RE: Review Comments for Final Plan

| Project Name: | CONDOMINIUM CONVERSION | Project ID: | 2011-258 |
| Address: | 130 EASTERN PROMENADE | CBL: | 003-C-001 |

130 EASTERN PROMENADE

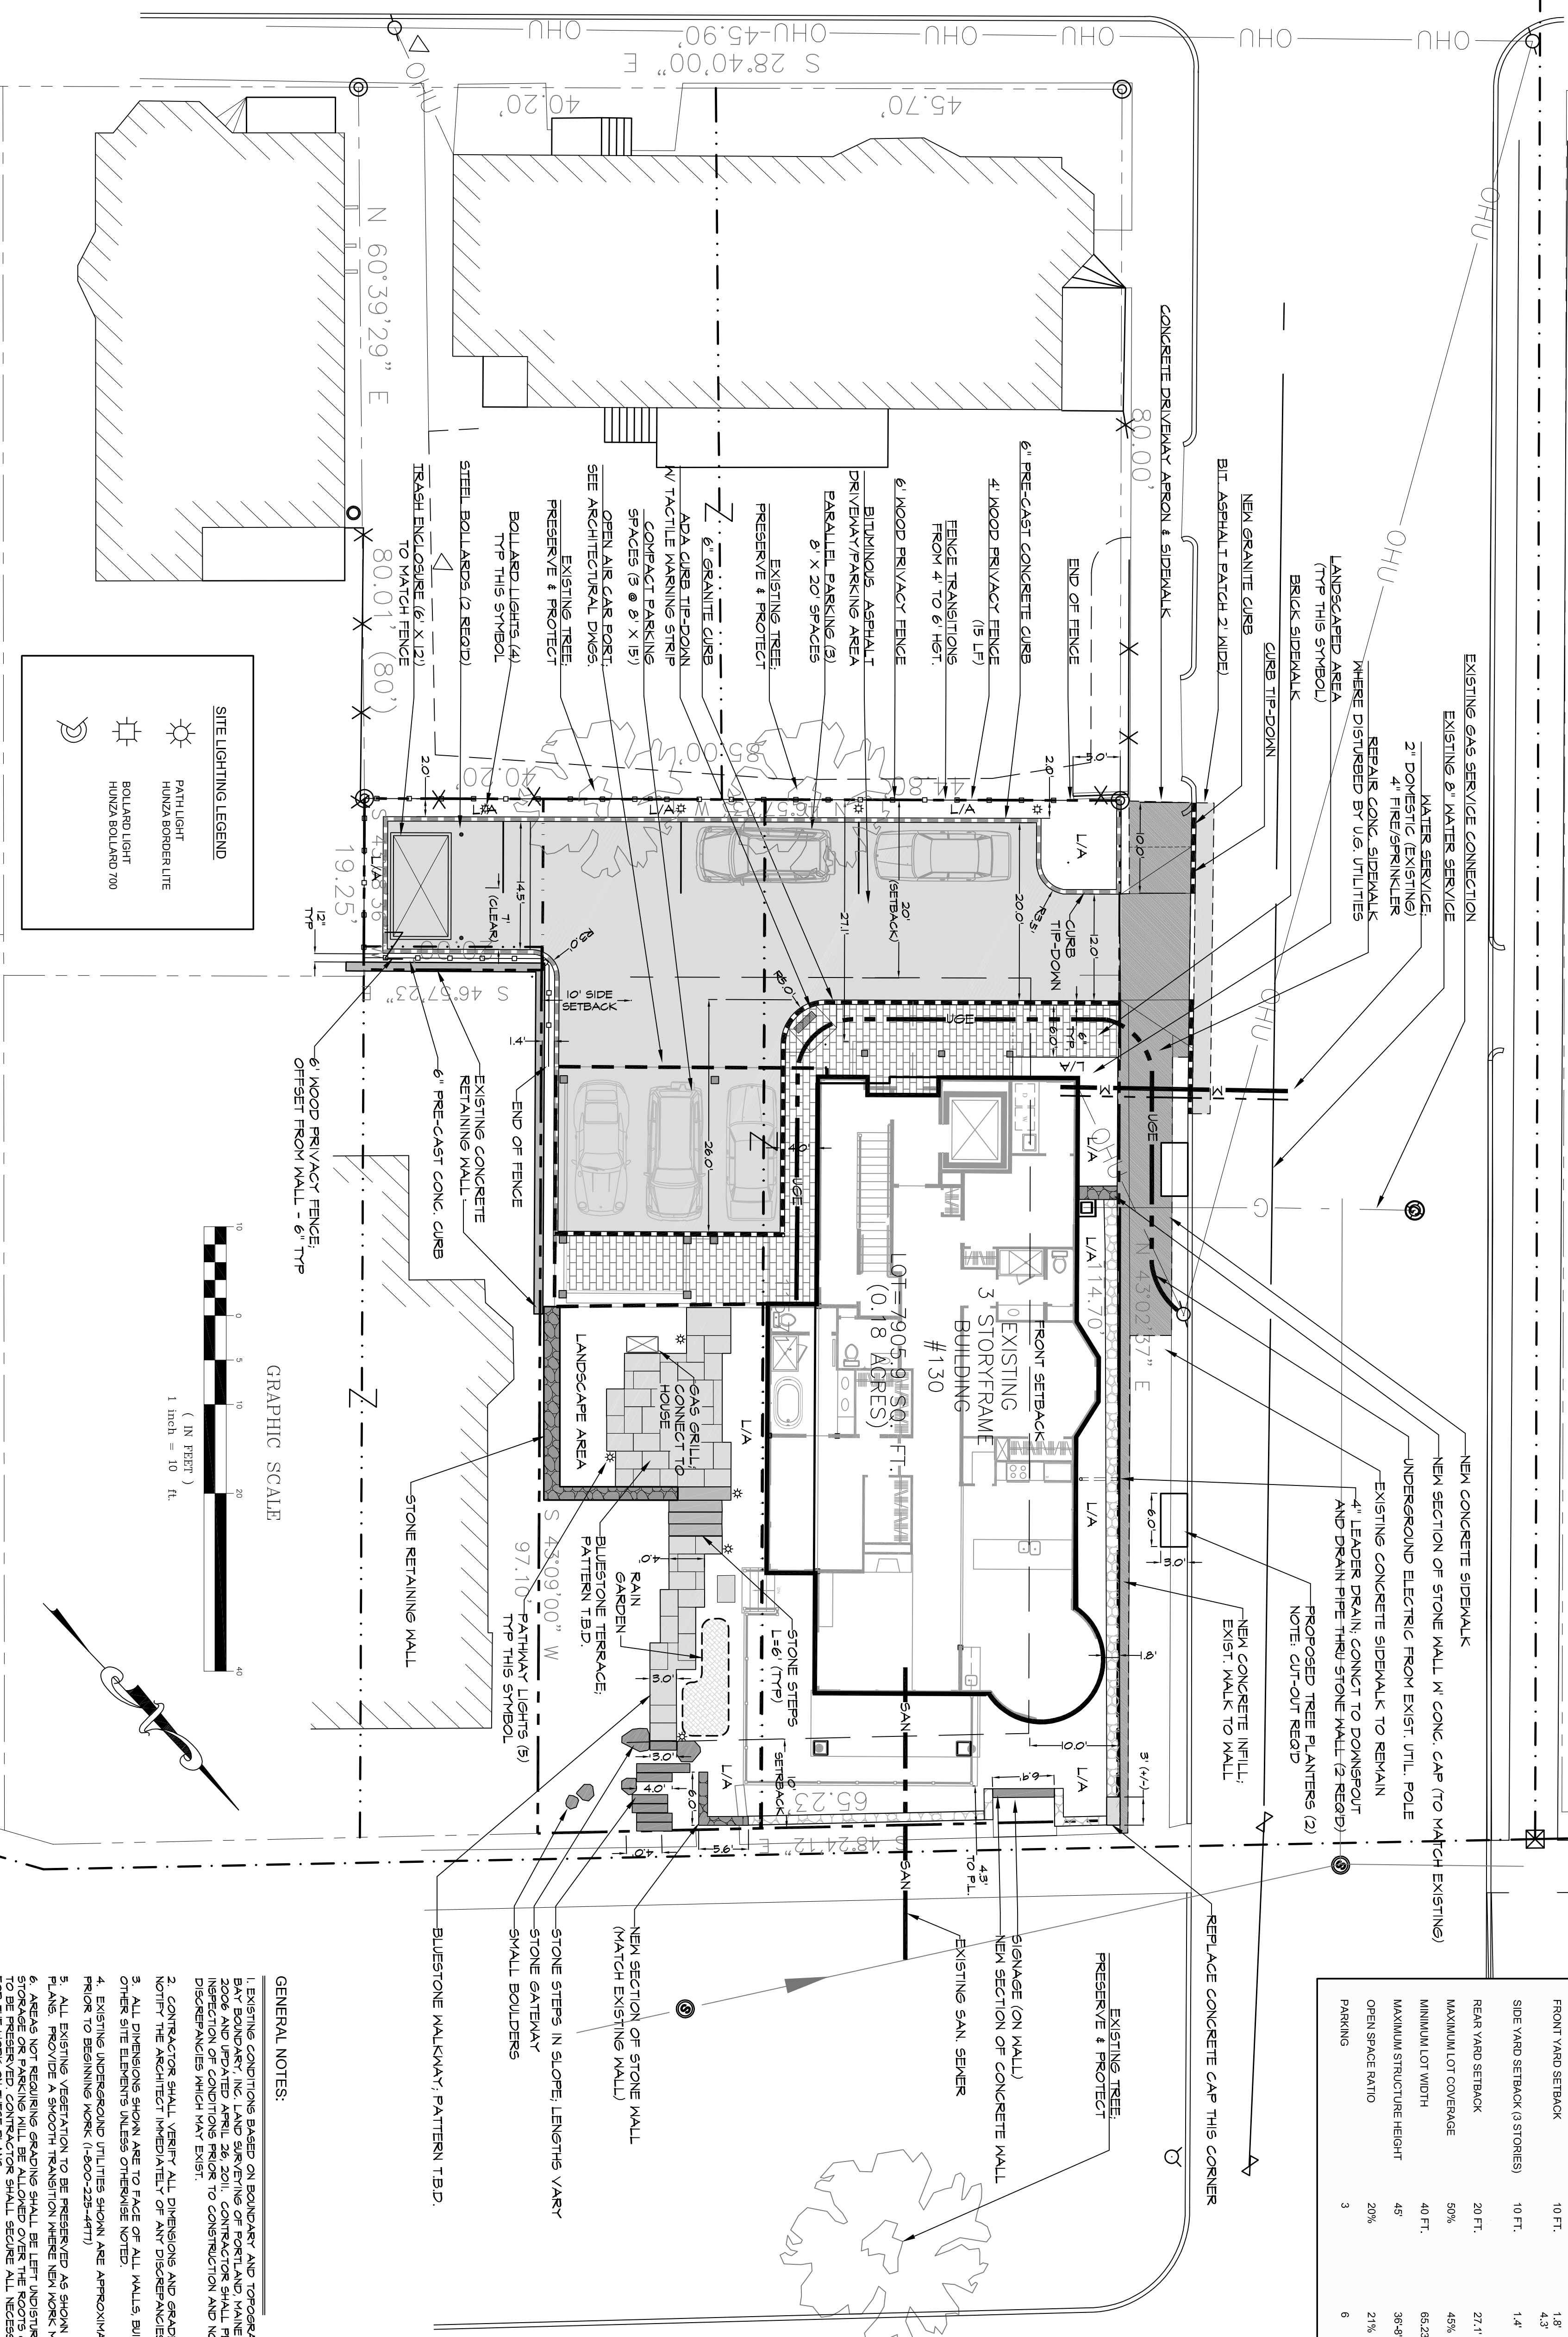
5. The standard parking spaces proposed for the site do not meet City standards. The spaces are proposed to be 8'x20'. The applicant should formally request a waiver and note why the standard can't be met.

6. The proposed parking circulation aisle width does not meet City standards. The applicant should formally request a waiver.
7. Access into and out of the parking space near the trash enclosure will be very difficult. The applicant should provide information that the noted space is reasonably accessible.

8. The applicant should provide information noting how vehicles will circulate from parking spaces. Is it the intent that vehicles will back onto Wilson Street?

12 STONE RETAINING WALL DETAIL

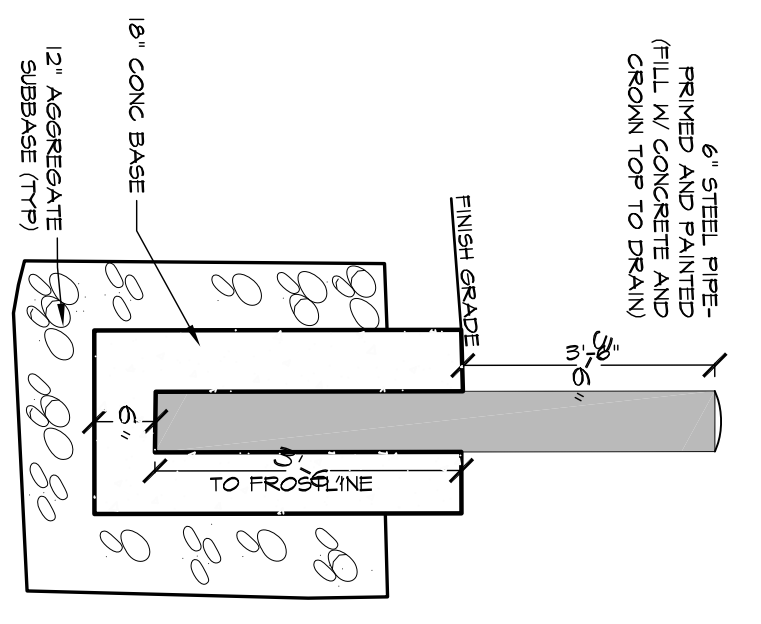
2. Retaining walls over four feet will need to have engineered details on the site plan.
3. Provide more information on the proposed fence, i.e. color, material, typical, etc.
